Your Ref: OWQC23255
Our Ref: EP/47/19/HH
Please ask for:
Mr Z Denton

31st May 2019

Two storey side extension to include a double garage, single storey rear extension,
single storey front extension and altered vehicle access to property
11 Michel Grove East Preston

Proposed Elevations
1:100

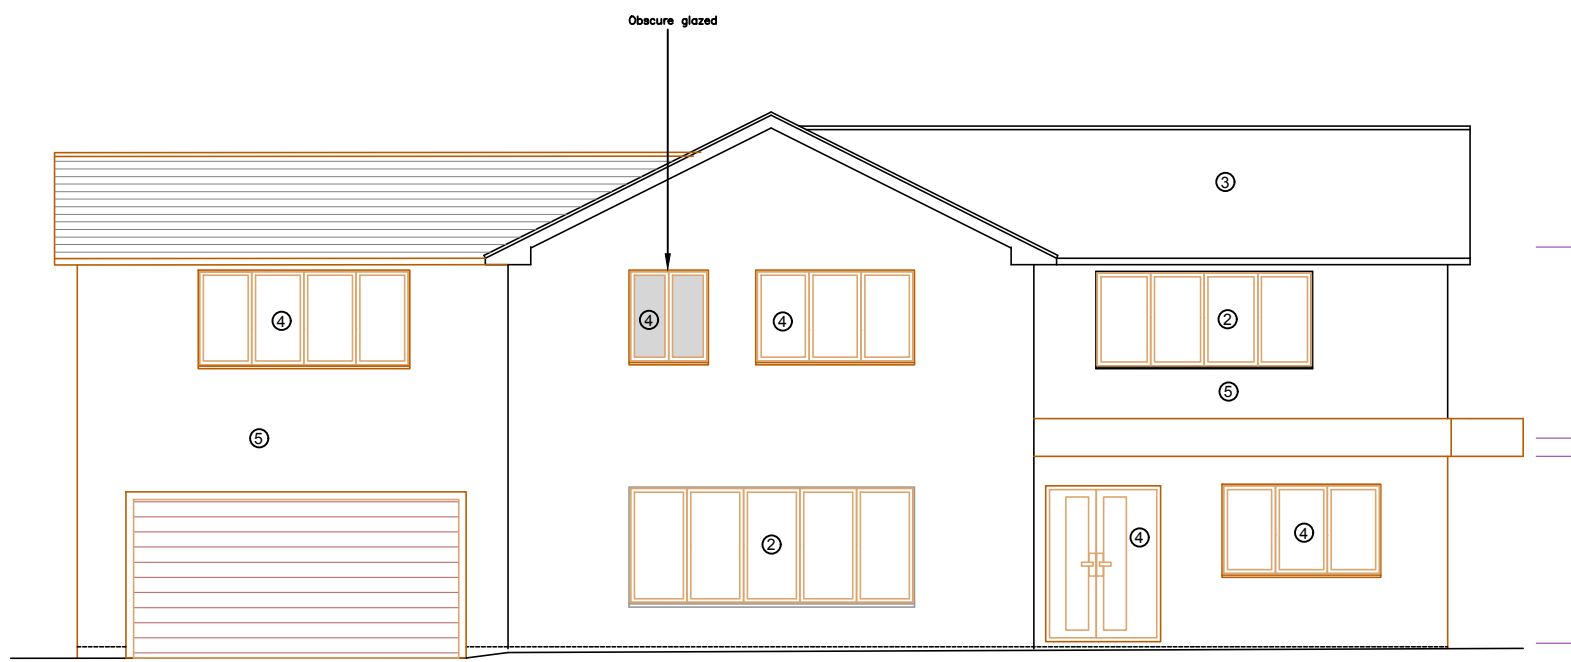
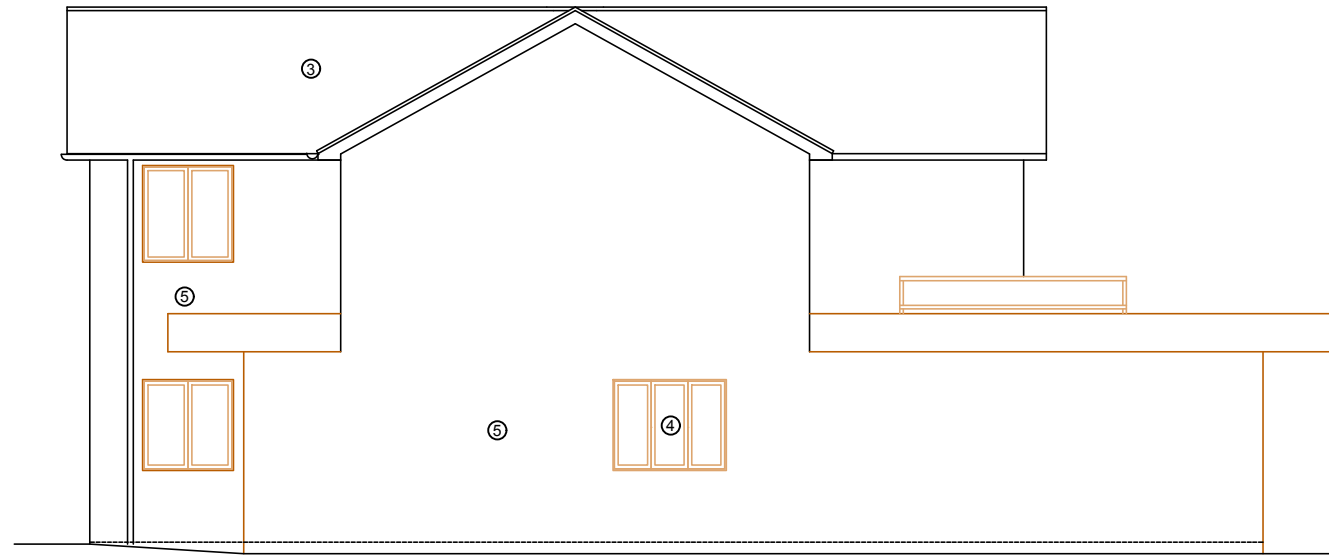
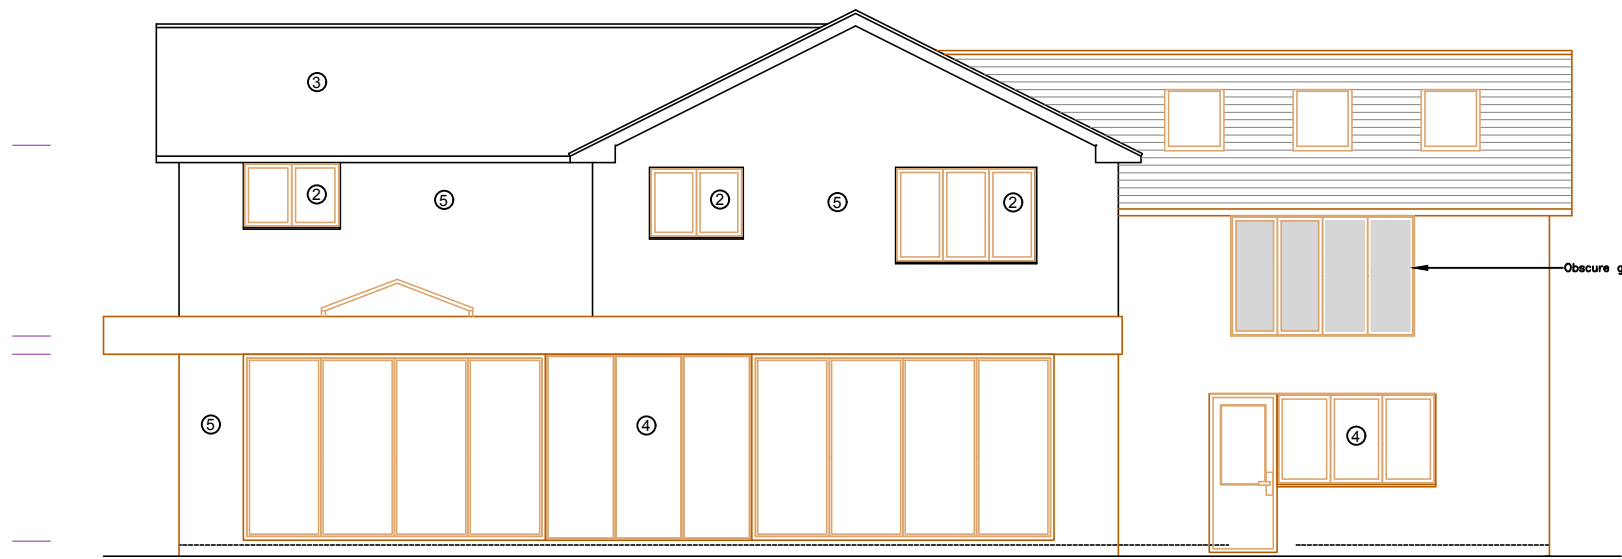
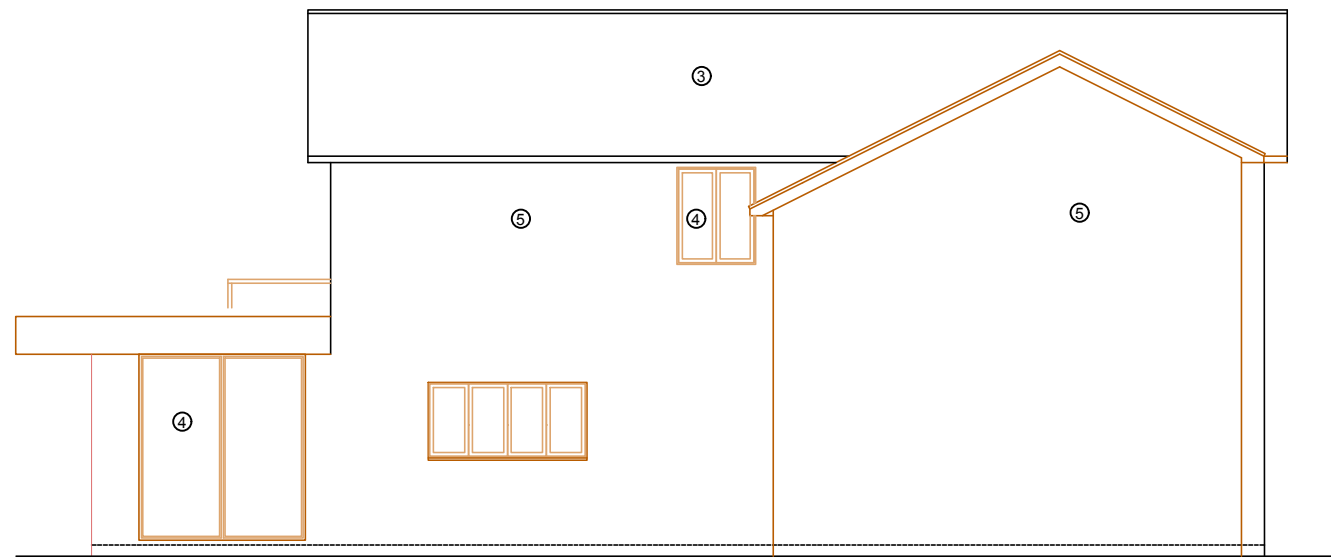
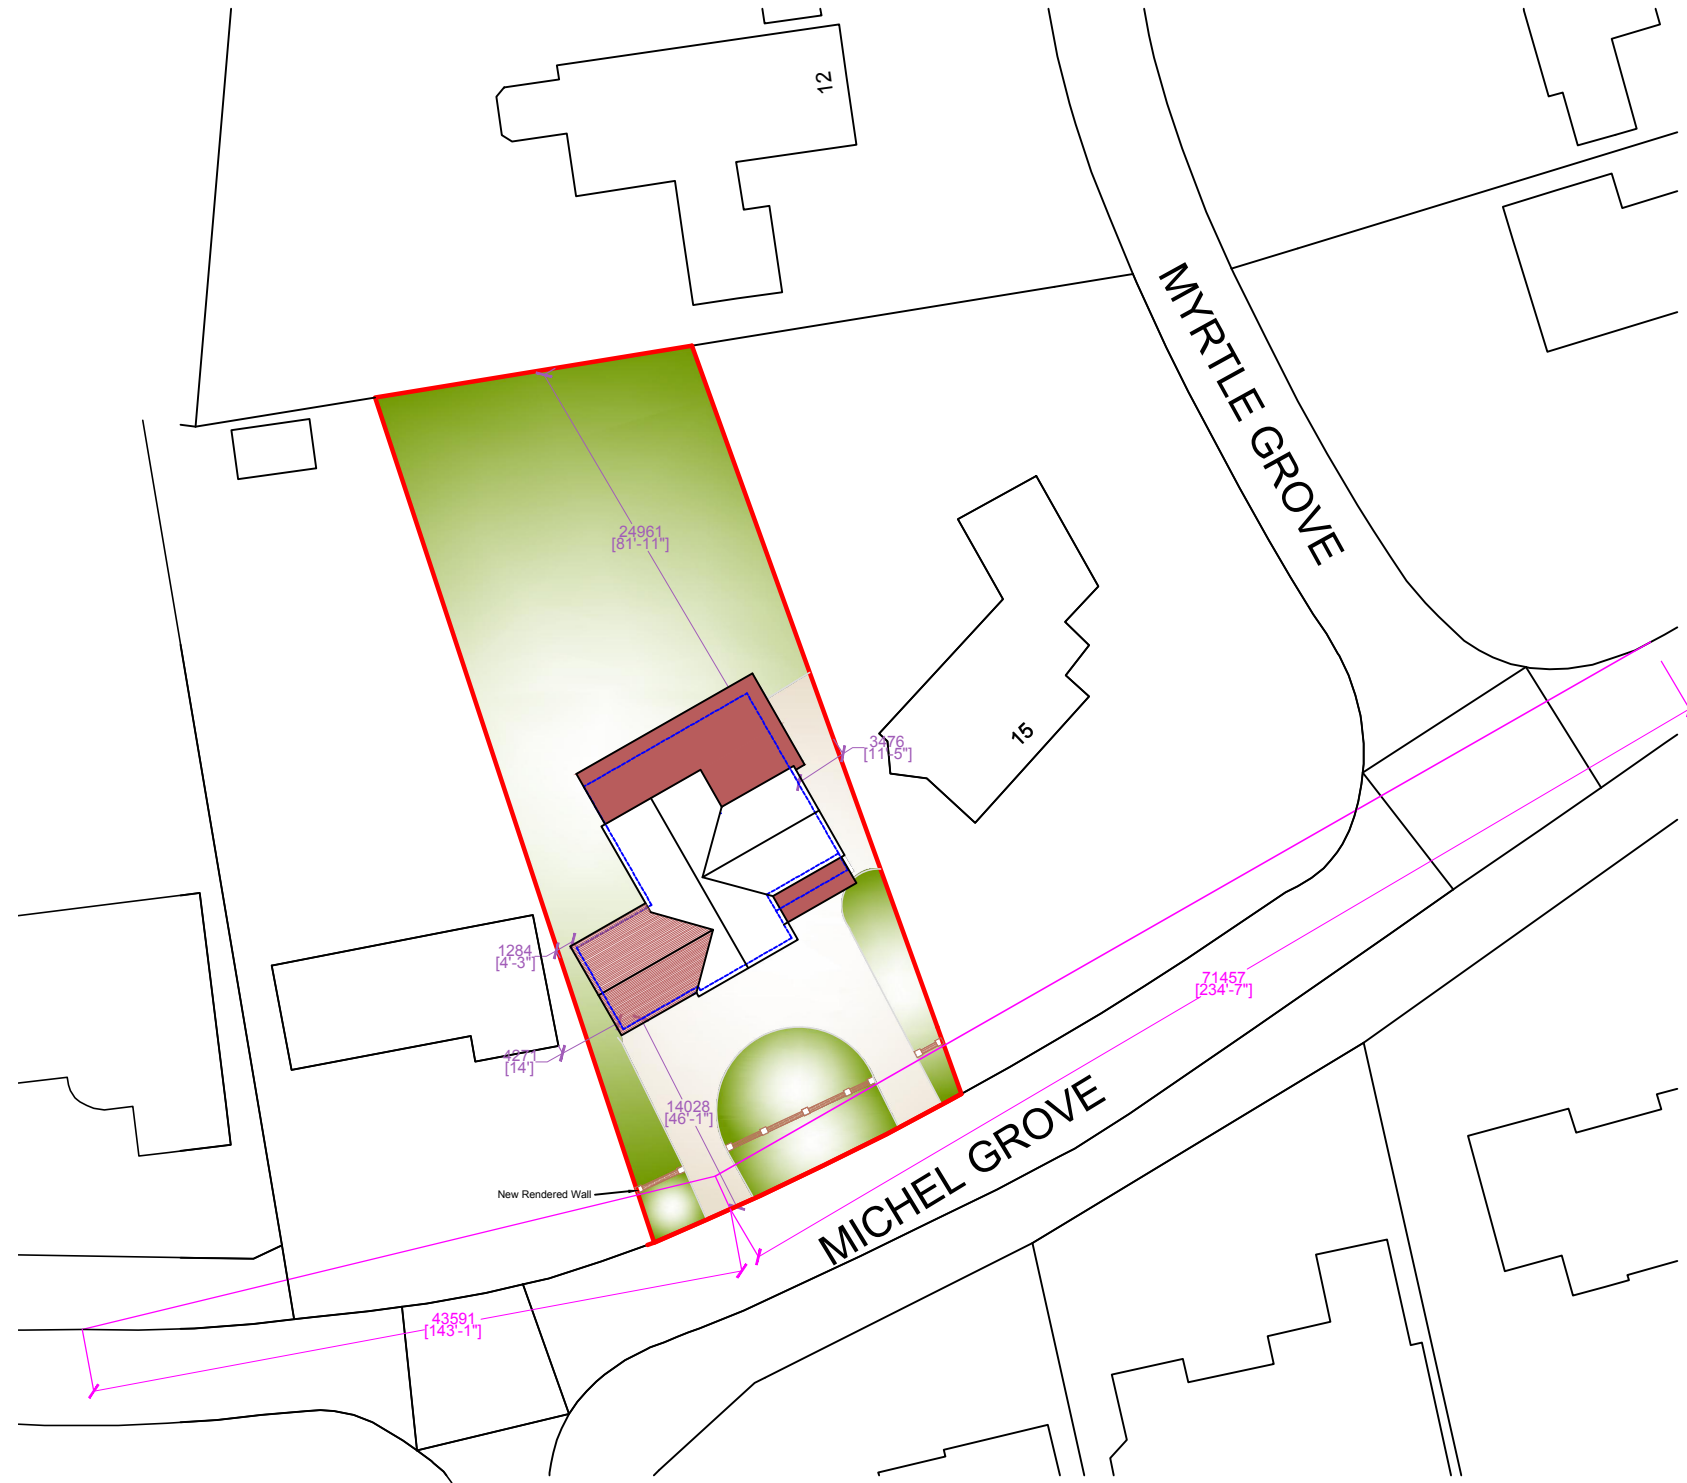
*The committee agreed to object to this Application on the following grounds. The proximity
of the proposed development to the western boundary will be contrary to Policy 2, Section
4.25 of the East Preston Neighbourhood Plan as the proposed extension may mean the
property does not "remain proportionate to their site."*

*The committee felt the proposal was also contrary to the Policy D DM4(e) of the Arun
Local Plan as it may "compromise the established spatial character and pattern of the
place".*
